Online Comment

Application H06-0372-21
Location Tilsons Yard Black Barn Main Road Gedney Drove End PE12 9PA
Proposal Details of external materials, external boxes, gas flues & soil vent pipes, landscaping, foul & surface water disposal and scheme to deal with contamination (Conditions 3, 4, 5, 6 & 7 of H06-0772-19)

Name Sue Armour
Address Environmental Protection Officer SHDC PE11 2XE

Date Submitted 27-05-21
For/Against Comments

**Exploratory Location Plan
(Over Proposed Layout)**

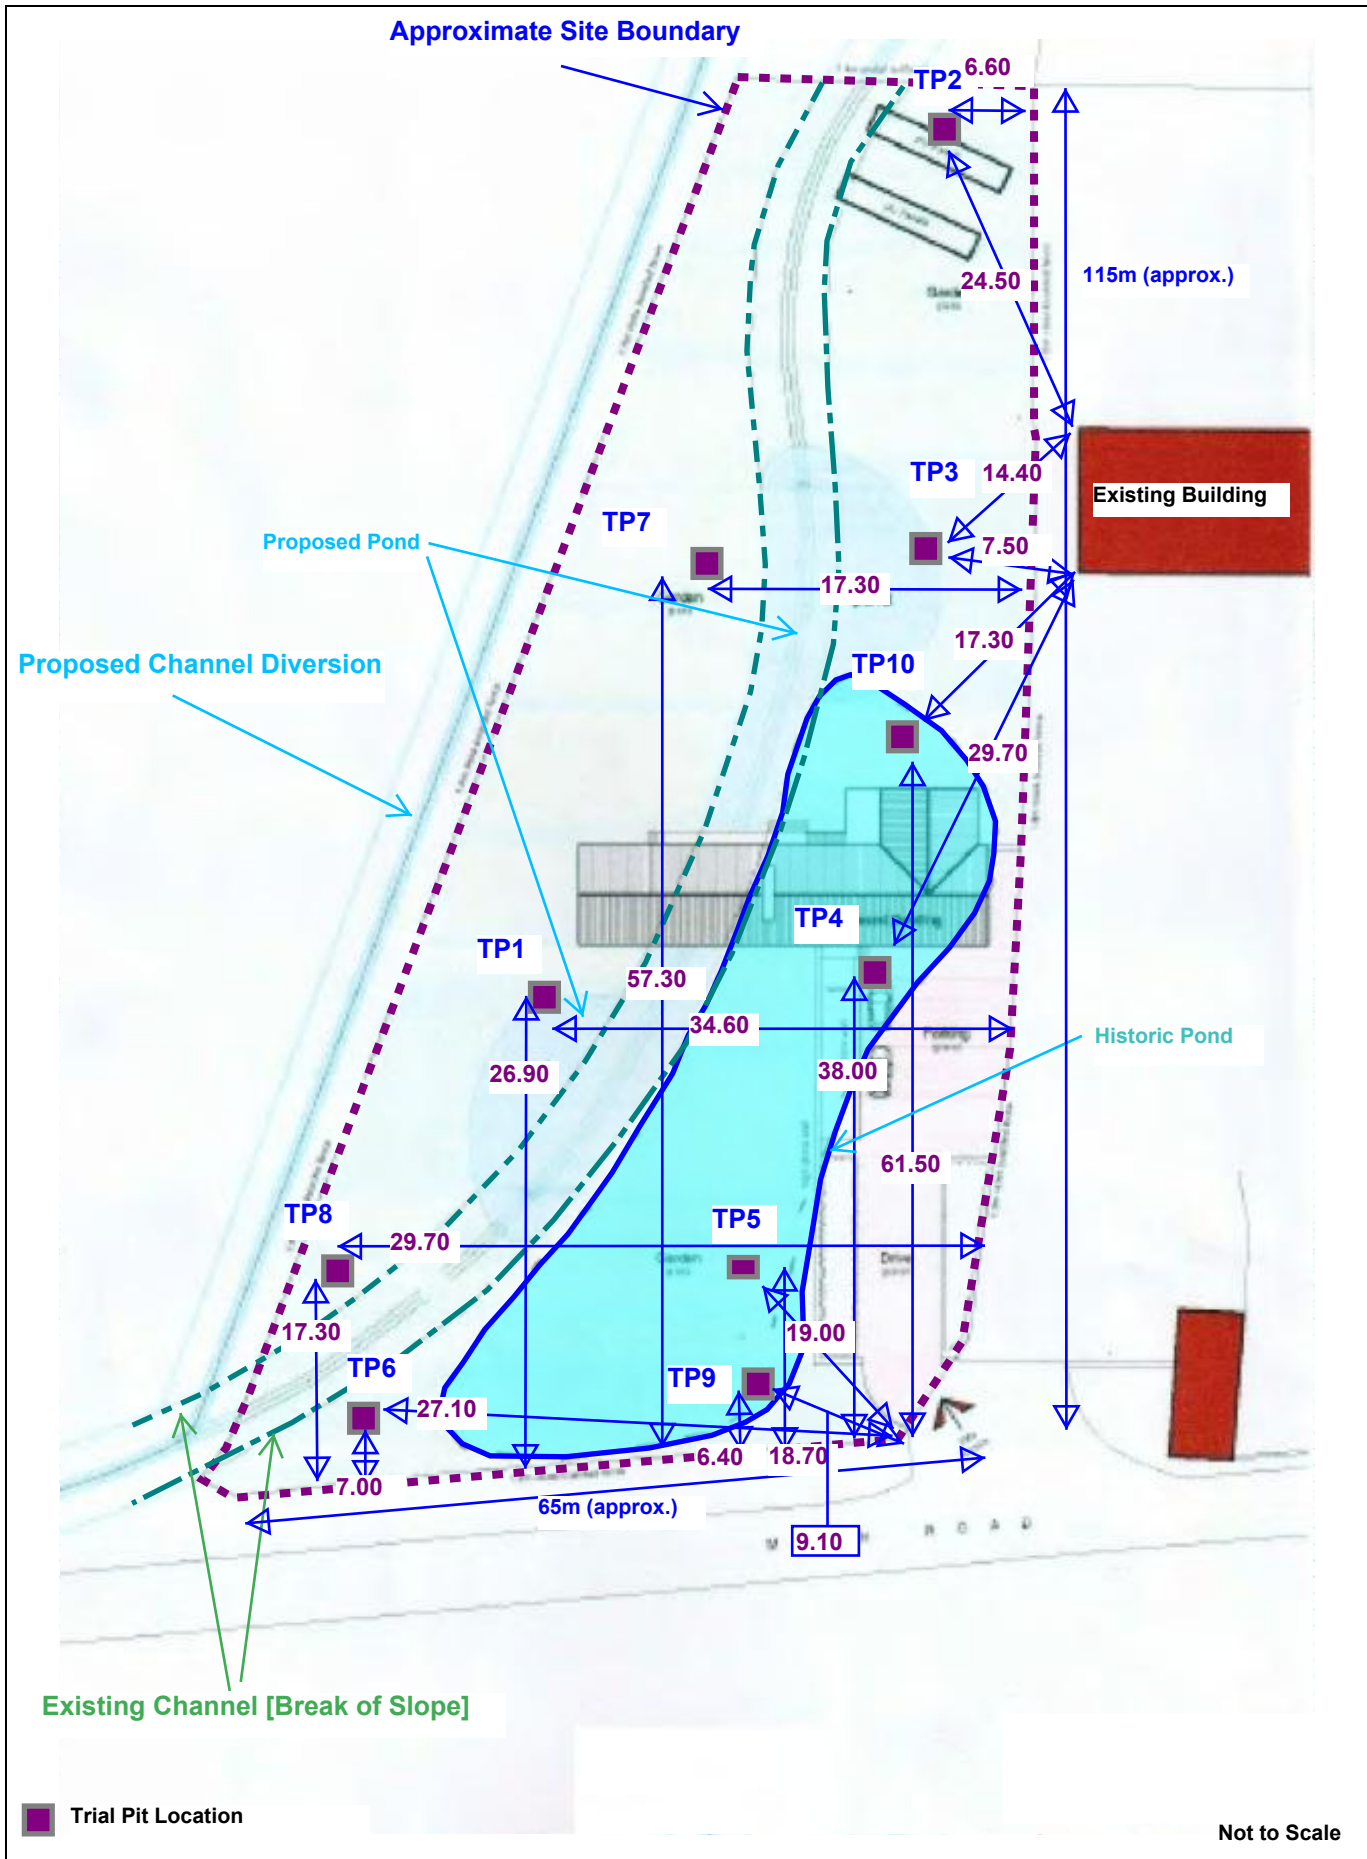
I have reviewed the Goldfinch Environmental Report 'Proposed residential development, Tilson Yard, Black Barn, Gedney Marsh, Spalding, Lincs. Geoenvironmental Desk Study' report reference 0548/1 and make the following comments: The historical mapping shows a pond which covers a significant part (approximately 50%) of the site. The pond is shown on each map edition from the 1880's until the 1970's. I therefore consider it be unlikely that this was an 'overspill area' - it would be extremely unlikely that a temporary overspill area was mapped with such frequency and at the same spatial extent. At the current time the report has not presented enough factual information relating to the pond and its potential for infill, and as such no conclusions can be drawn with respect to the need, or not, for ground gas protection measures or the suitability for residential use. I therefore consider that some exploratory investigation is required at this location to reduce the uncertainty and establish the suitability for the proposed residential use.

I note that the report was prepared for a previous site layout, this should be addressed in any further work undertaken.
